**Re: Whataburger, 111 Coors Boulevard NW
Grading Plan and Drainage Plan
Engineer's Stamp Date 12-2-14 (K10D001B)**

Amy L. D. Niese, P.E.
Senior Engineer, Hydrology
Planning Department

ENGINEER'S SEAL	WHATABURGER COORS AND CENTRAL	DRAWN BY B.J.F.
		STORMCHAMBER STORAGE SYSTEM	DATE 11/05/14
			2014075_GRB
			SHEET # C3
	RONALD R. BOHANNAN P.E. #7868	TIERRA WEST, LLC 5571 MIDWAY PARK PLACE NE ALBUQUERQUE, NM 87109 (505) 858-3100 www.tierrawestllc.com	JOB # 2014075

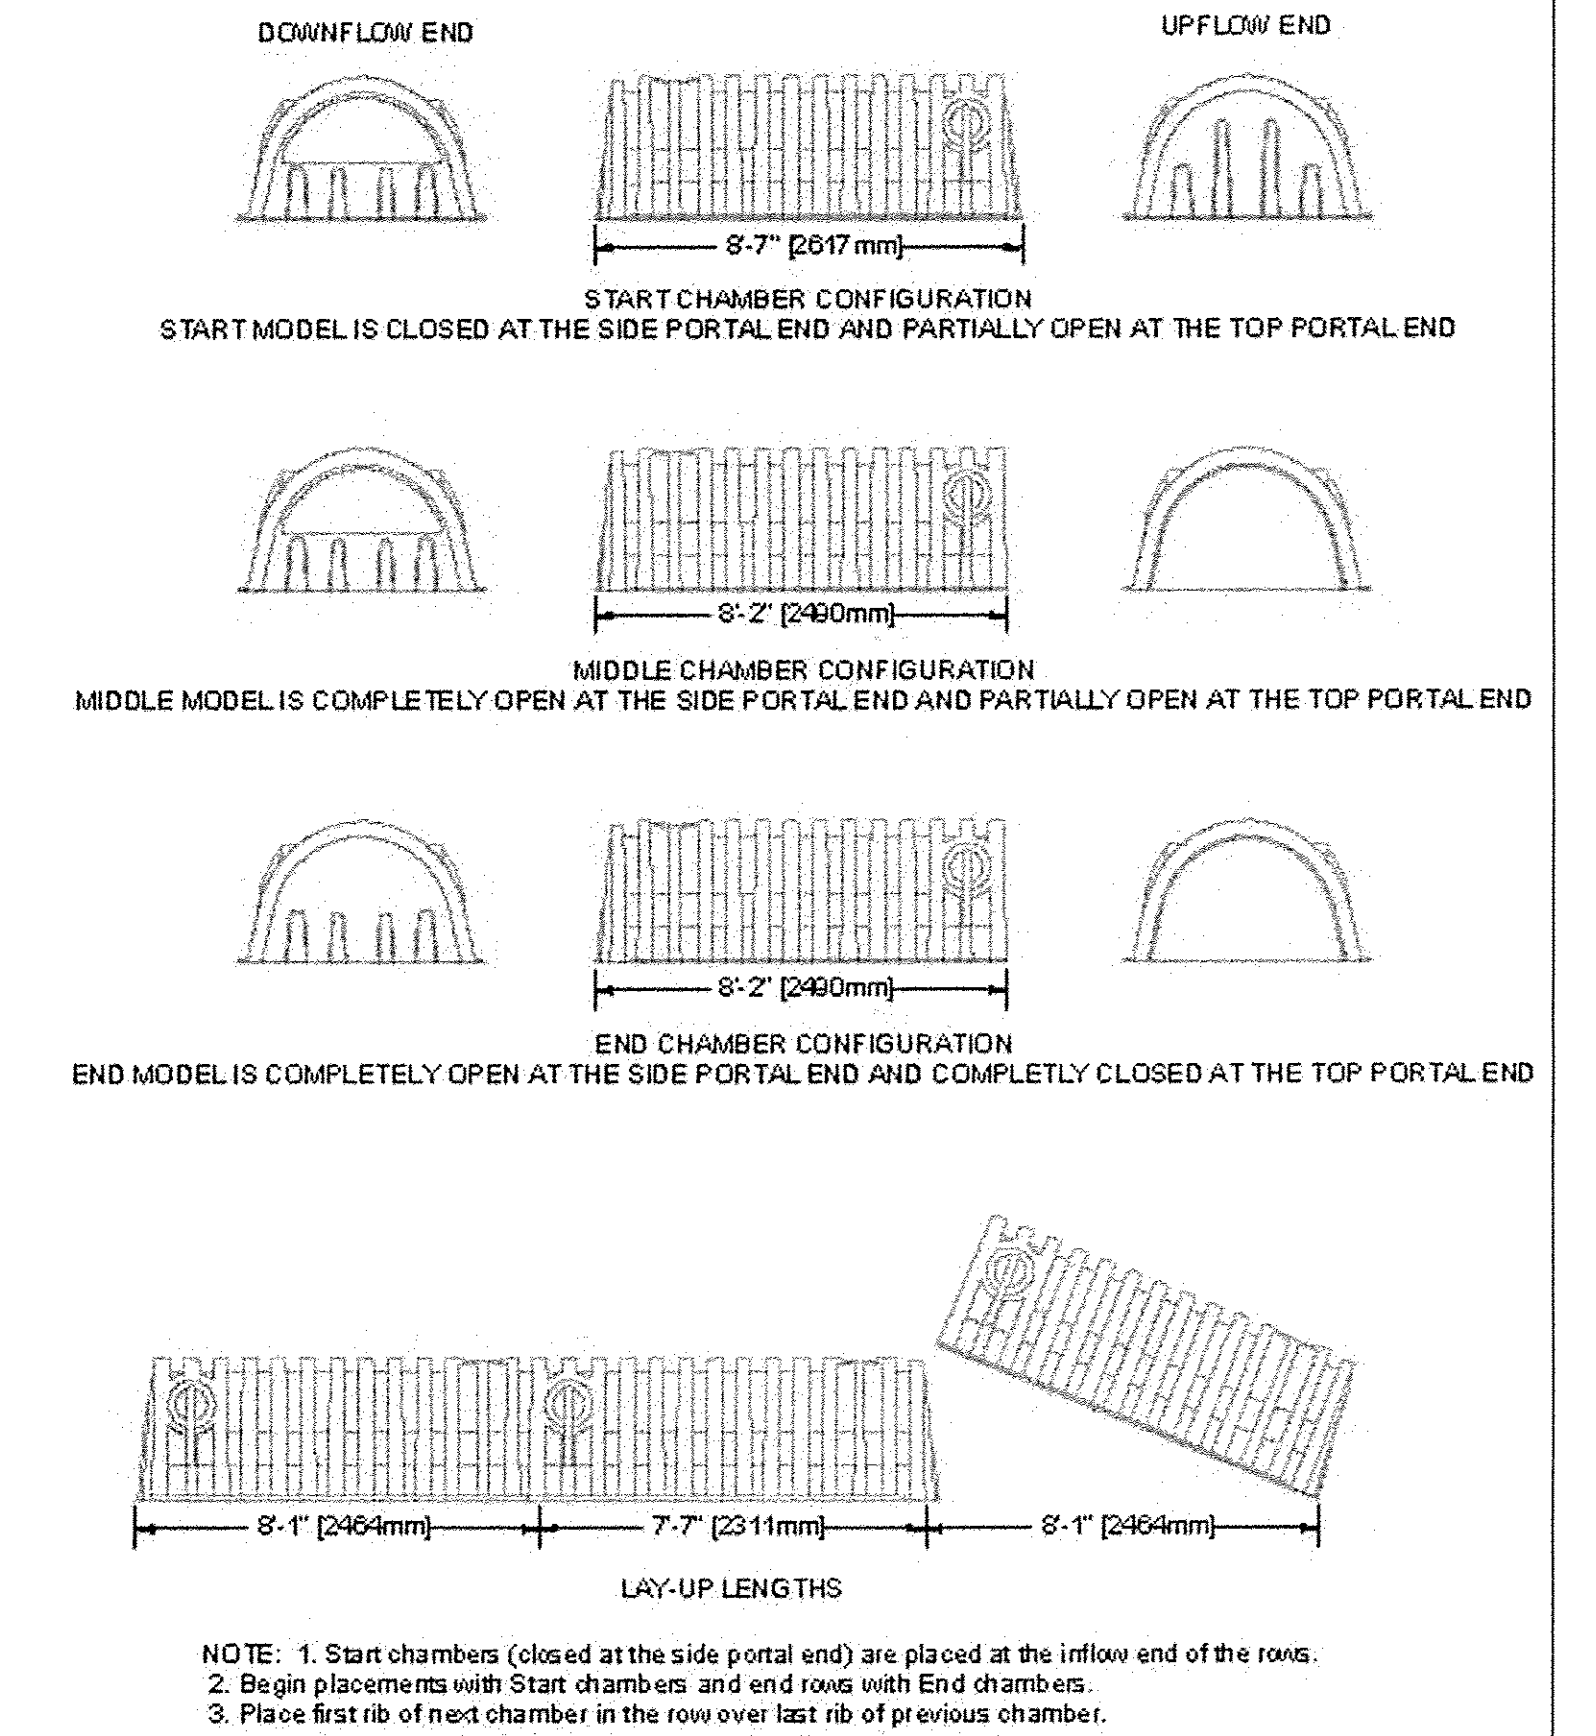
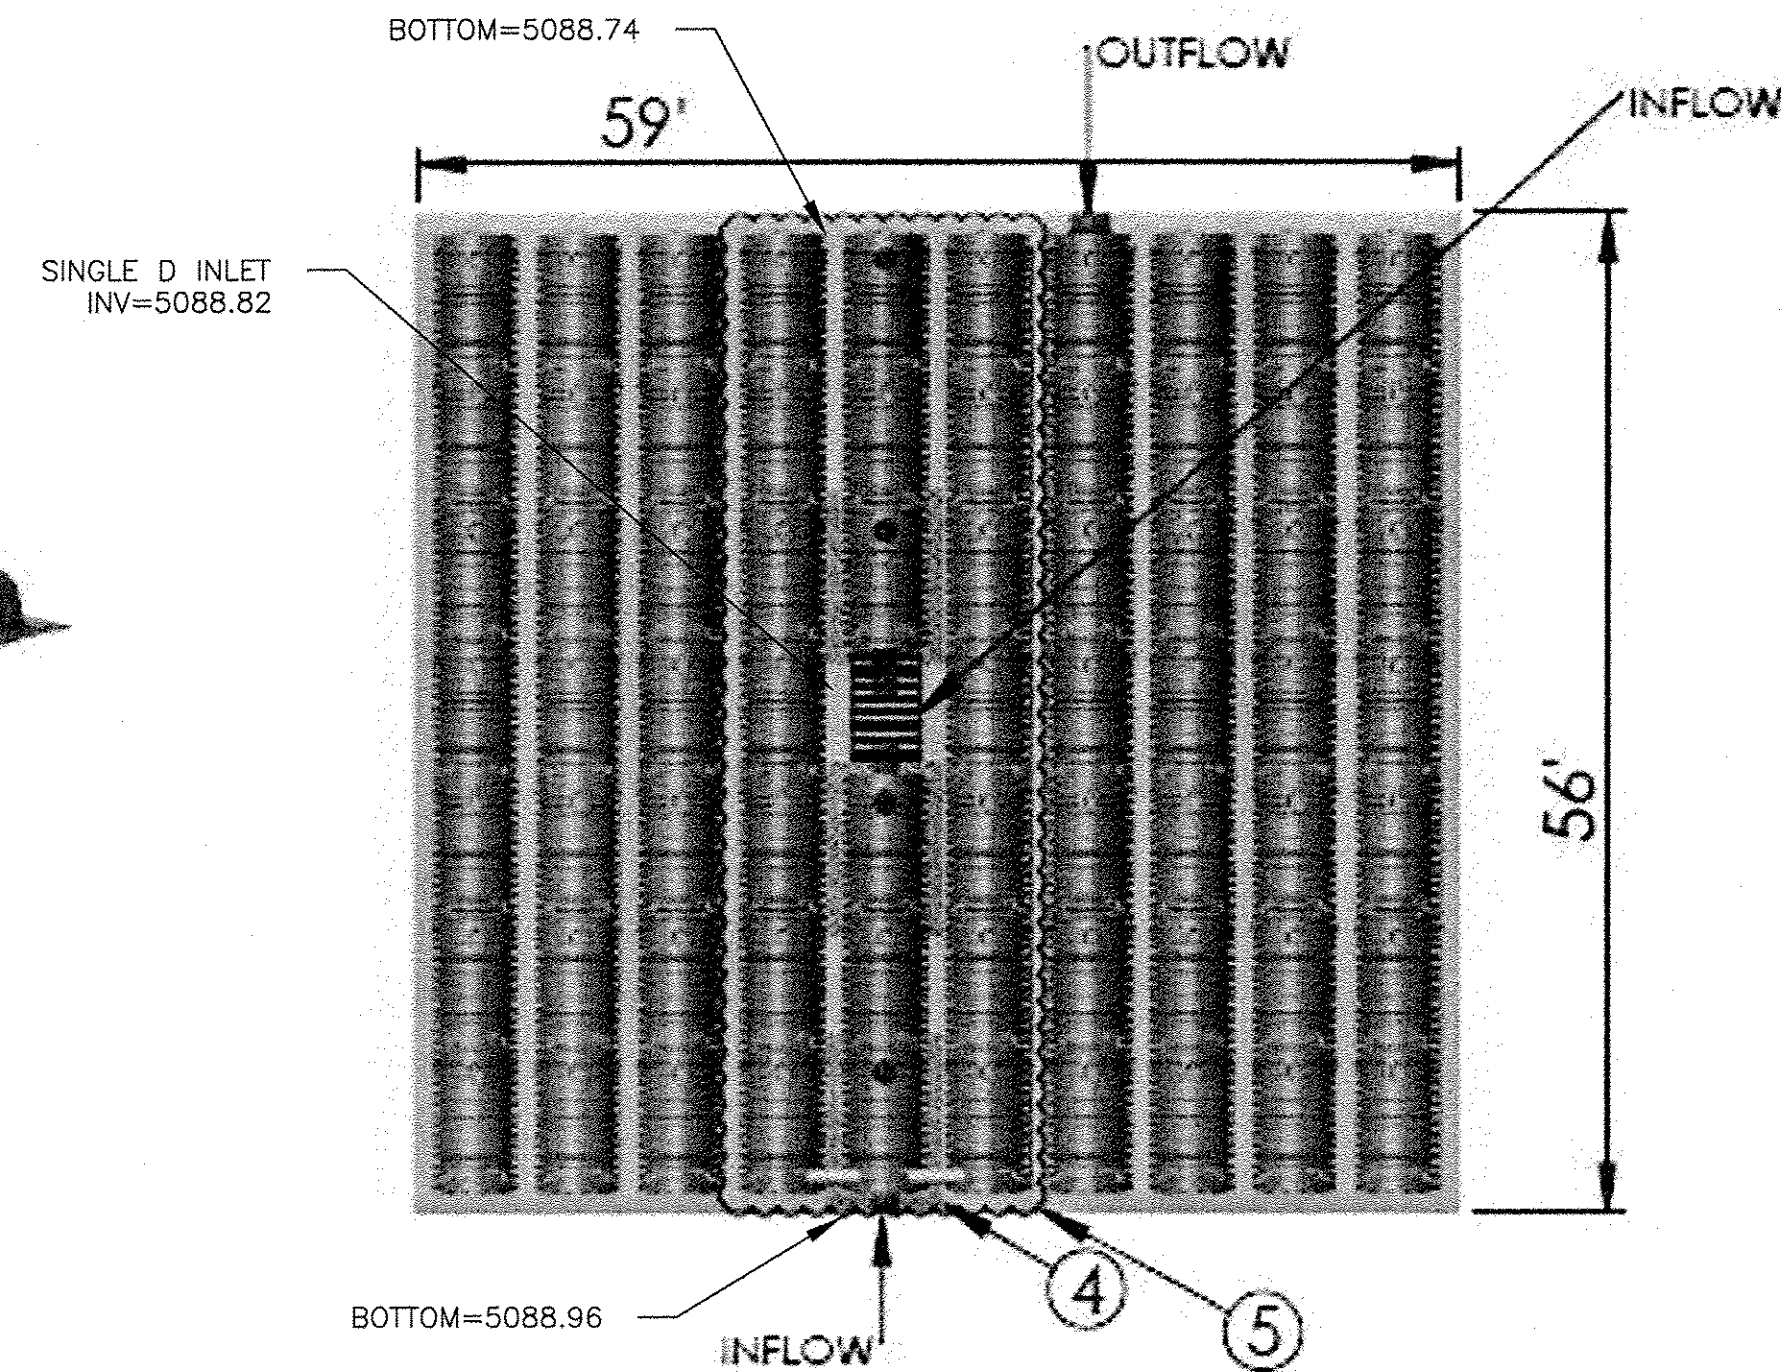
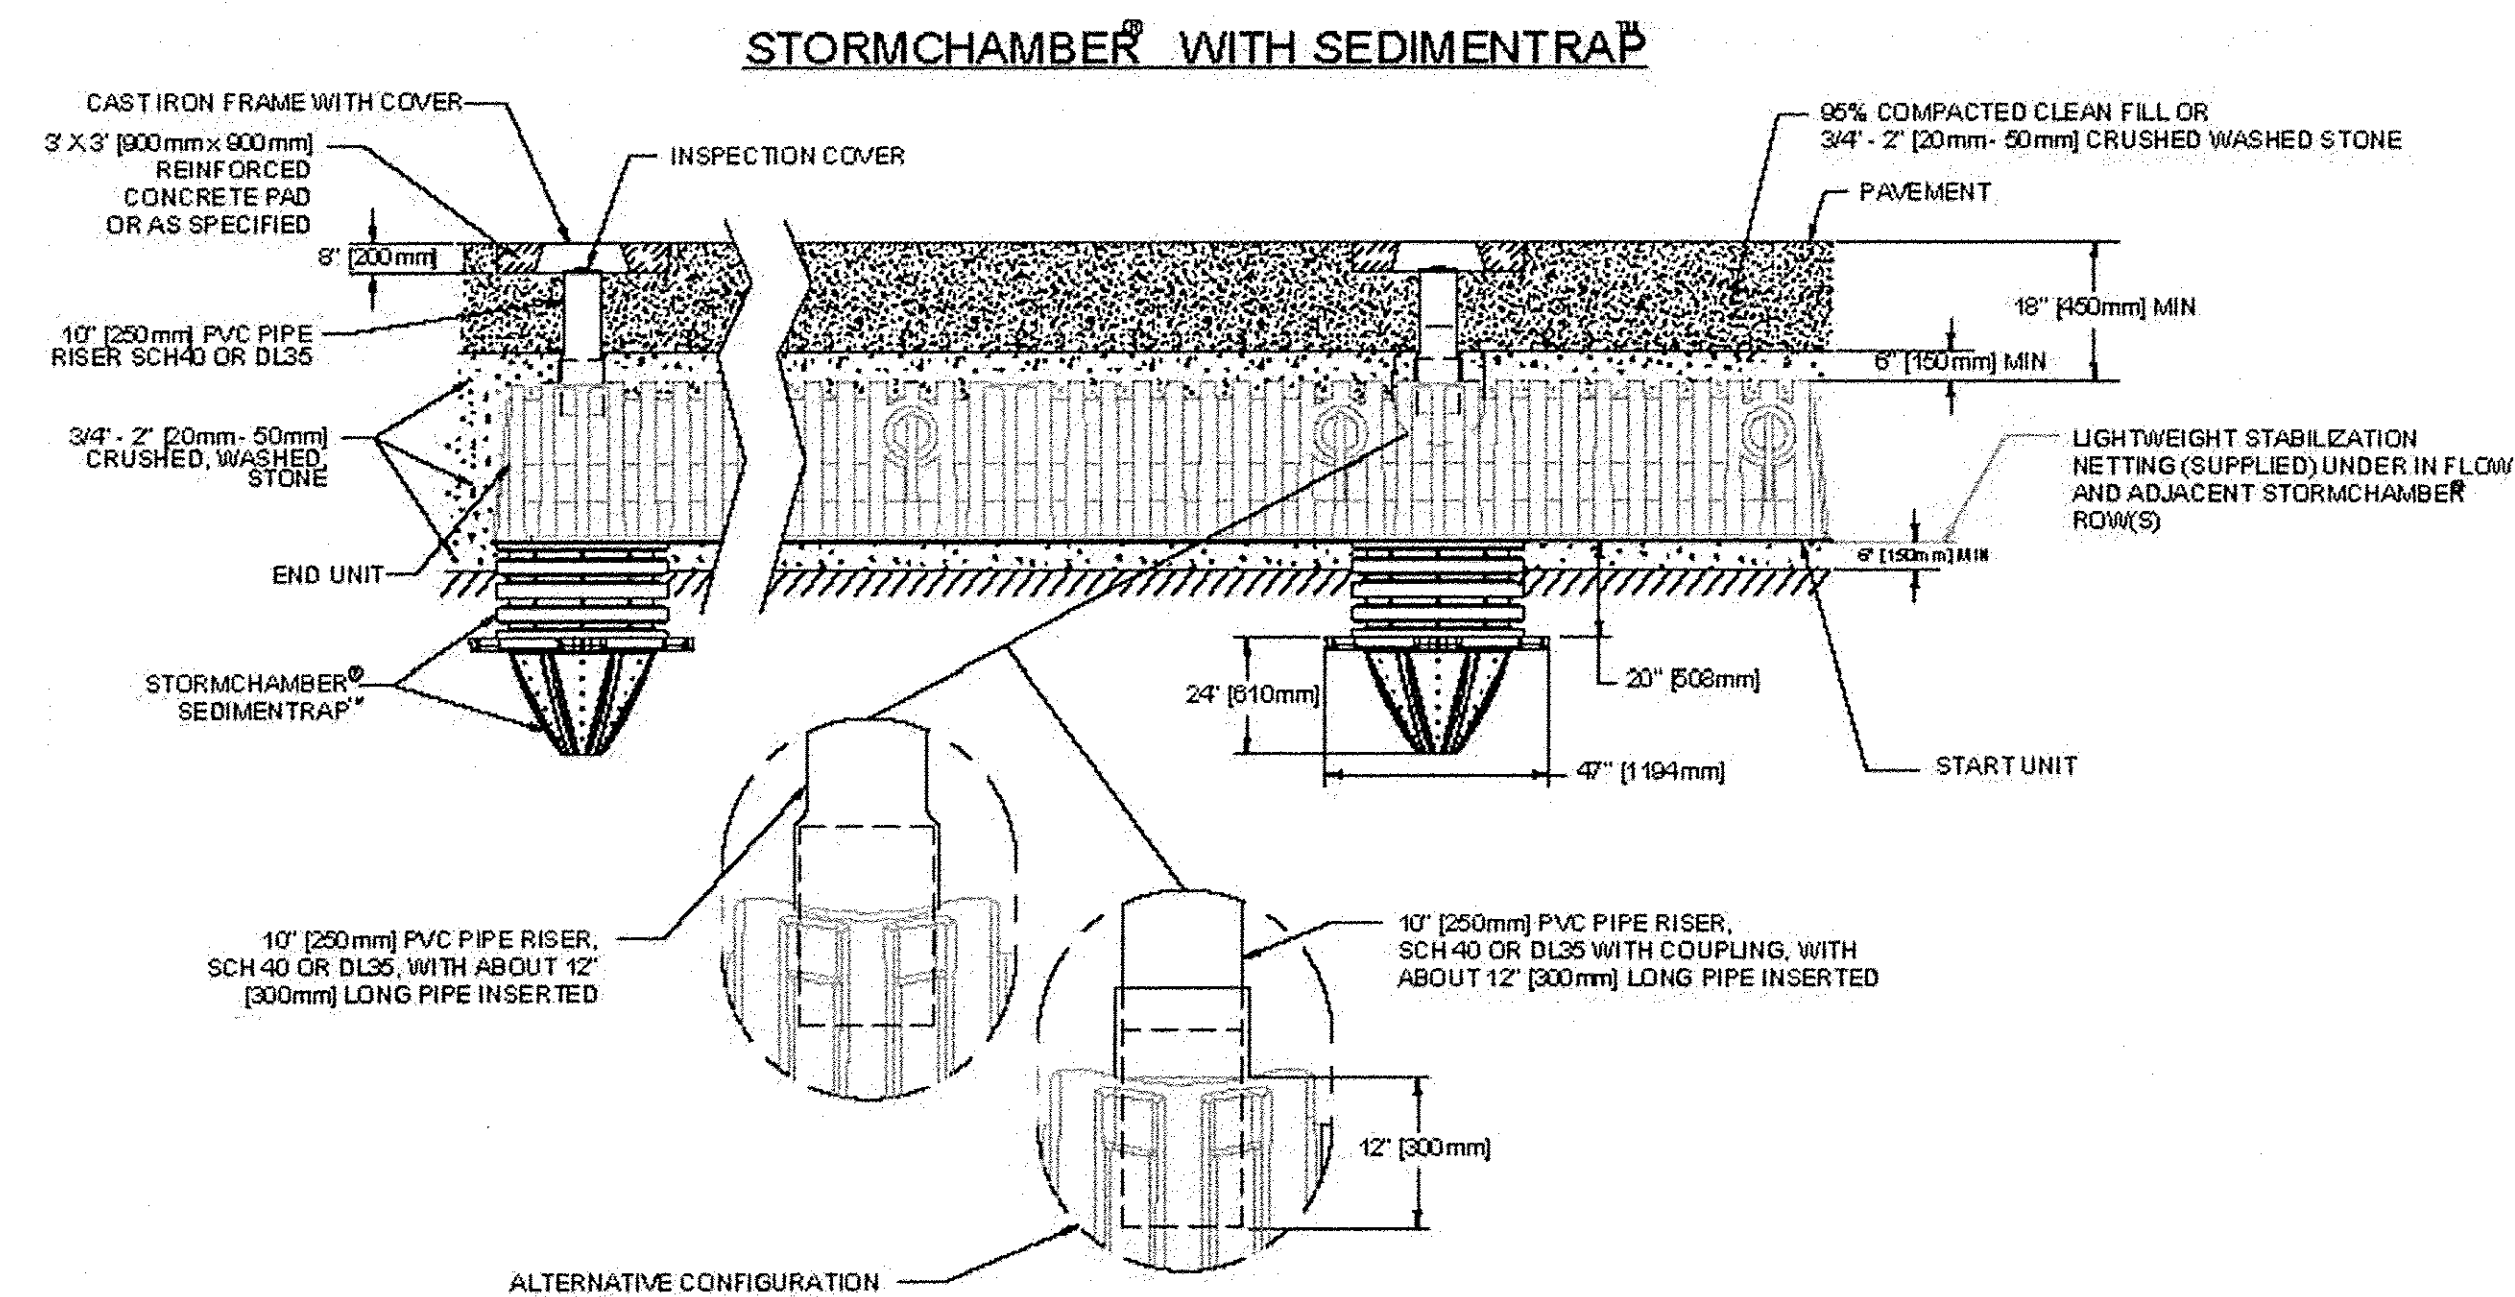
4. How was the Stormchamber sizing determined? How many risers will be with this system? Is the only riser the inlet in the middle of the system? If more than one, where will they be located exactly? On the Stormchamber detail sheet, optional items are called out on the lower left cross-section detail. Will those options be utilized with this system?
